East Anglia One North (EA1N) and East Anglia Two (EA2) Offshore Wind Farms

Planning Inspectorate Reference: EA1N – EN010077, EA2 – EN010078

Deadline 2 - 17 November 2020

Comments of Suffolk County Council as Archaeological Authority

East Anglia ONE North and TWO
Appendix 24.3 Figure 16: Historic Parish Boundaries within the ADBA Study Area

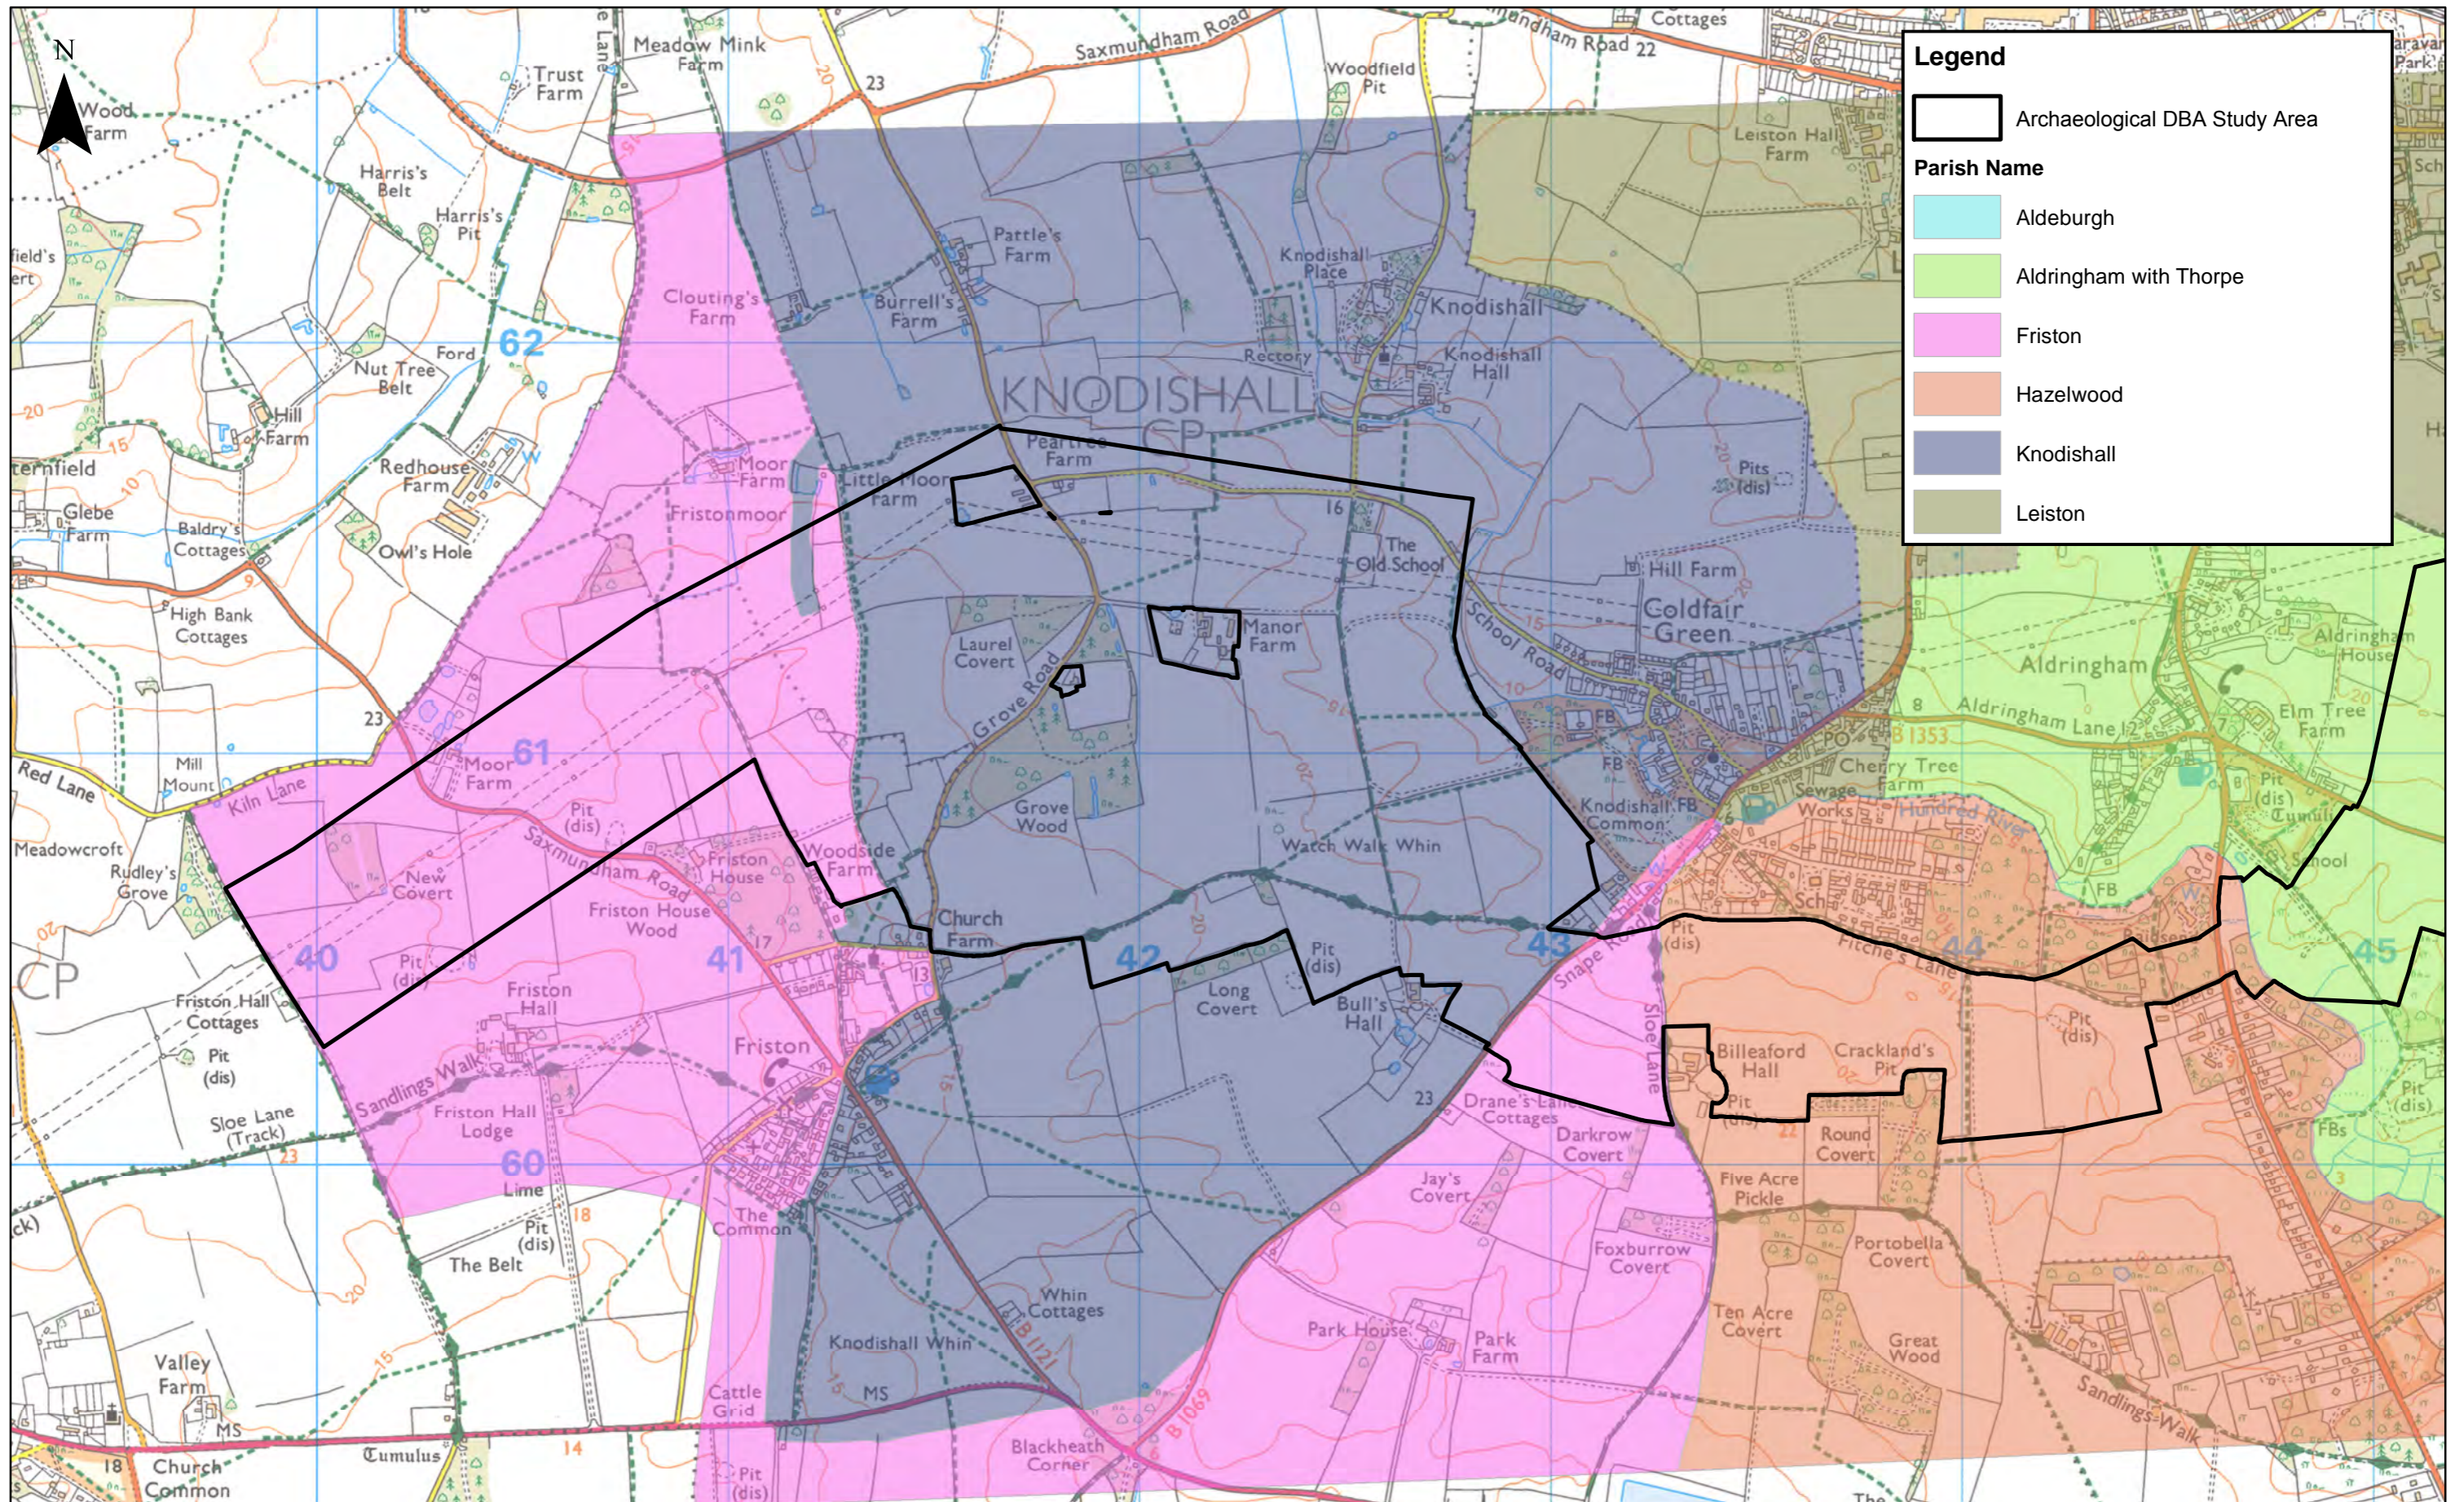
Regarding Applicant's Comments on Relevant Representations Volume 3 Technical Stakeholders 11th June 2020 2.4 Suffolk County Council 012- the Parish boundary is also identified as the Hundred boundary. This is further highlighted in SCC's Local Impact Report and Annexes.
